From: Sue Howell <Sue.Howell@arun.gov.uk>
Sent: 13 May 2021 18:37
To: Planning.Responses <Planning.Responses@arun.gov.uk>
Cc: Simon Davis <Simon.Davis@arun.gov.uk>
Subject: FW: Planning Consultation on: Y/49/21/RES

Application ref: Y/49/21/RES

Description: Approval of reserved matters following Y/92/17/OUT for 300 No. dwellings covering landscape, layout, scale & external appearance (resubmission following Y/78/20/RES). This application affects the setting of listed buildings, affects the character & appearance of the Main Road/Church Road, Yapton Conservation Area & affects a Right of Way. This site falls within Strategic Site SD7 (Zero Rated).

Location: Land East of Drove Lane Yapton BN18 0EB

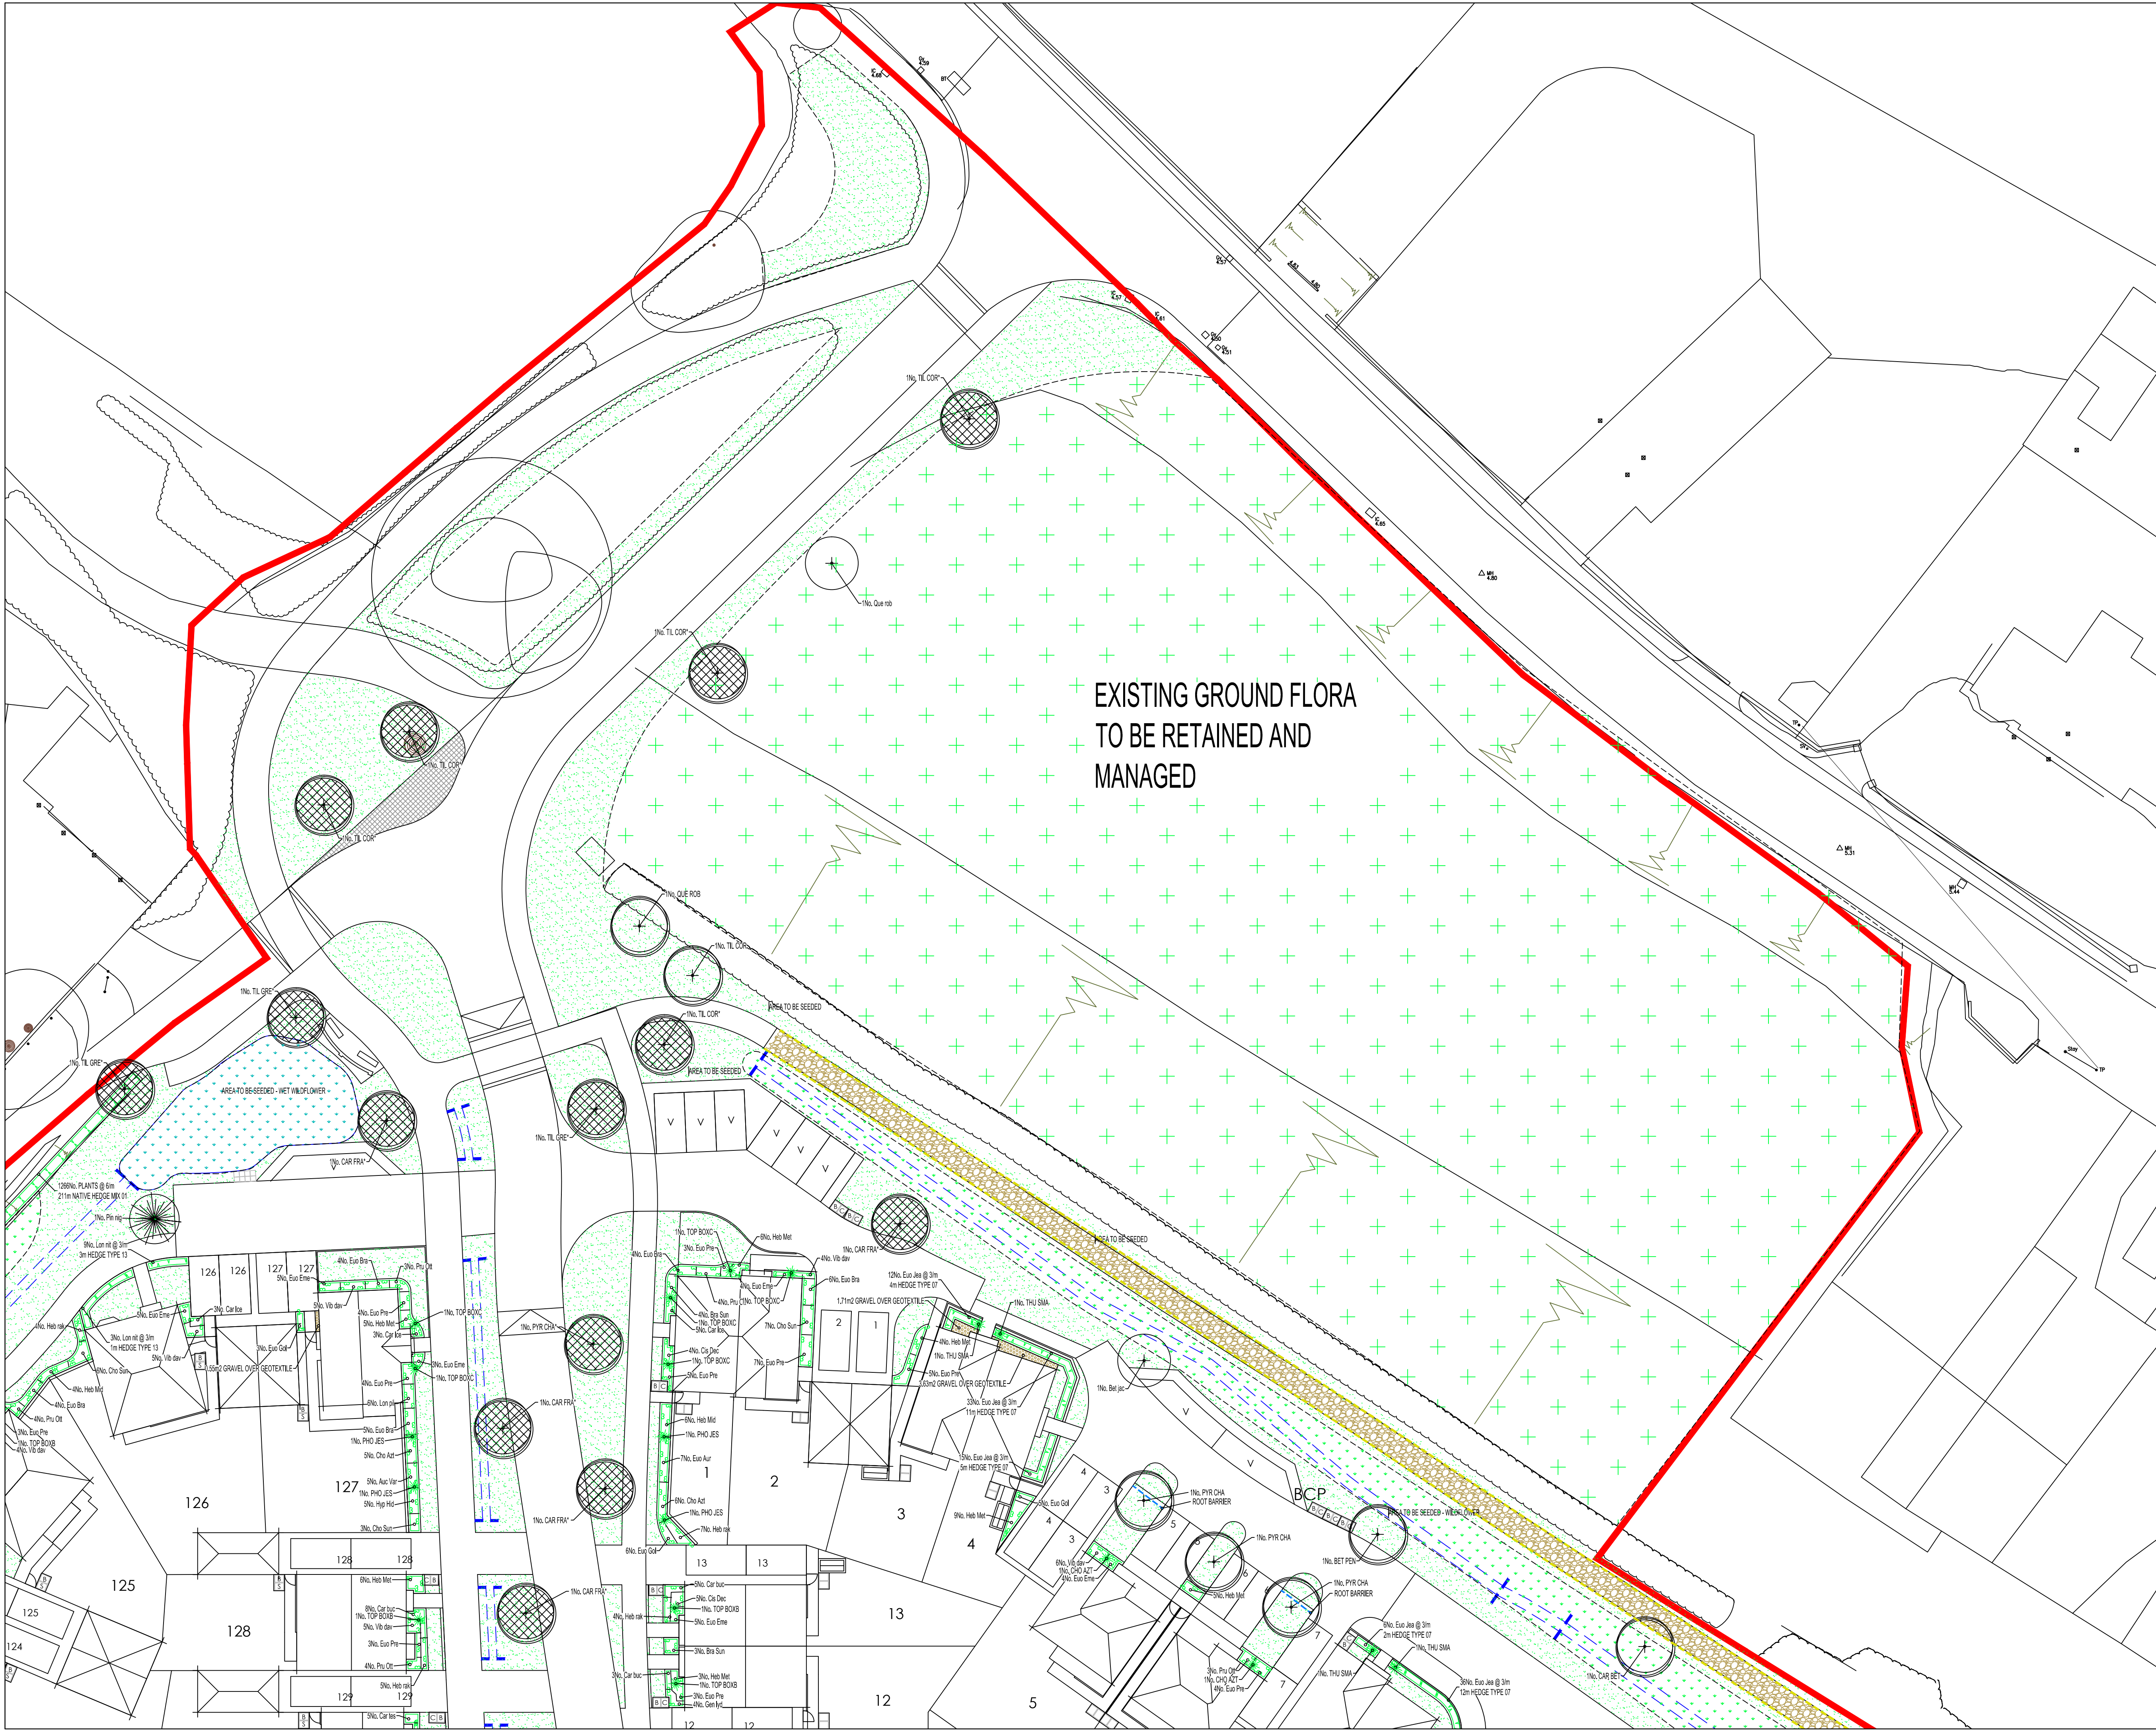
The drawing: Detailed soft landscape proposals for plots and hard and soft for POS JBA 19/291 – 08 Rev F details the central POS area where it is indicated for 'Play area location', 1no onsite LEAP and 2no onsite LAPs have been confirmed for inclusion within this development. Further detail will need to be submitted re the detailed provision in these locations. LAPS are intended to be very much natural areas of play and therefore potentially not fenced areas. The LEAP needs to demonstrate good play experiences with inclusive and accessible provision.

Detail to be submitted re the equipment choice, surfacing, fencing and connectivity to the pathway network for the formal play LEAP and the design thought for the more informal natural based play space – LAPs
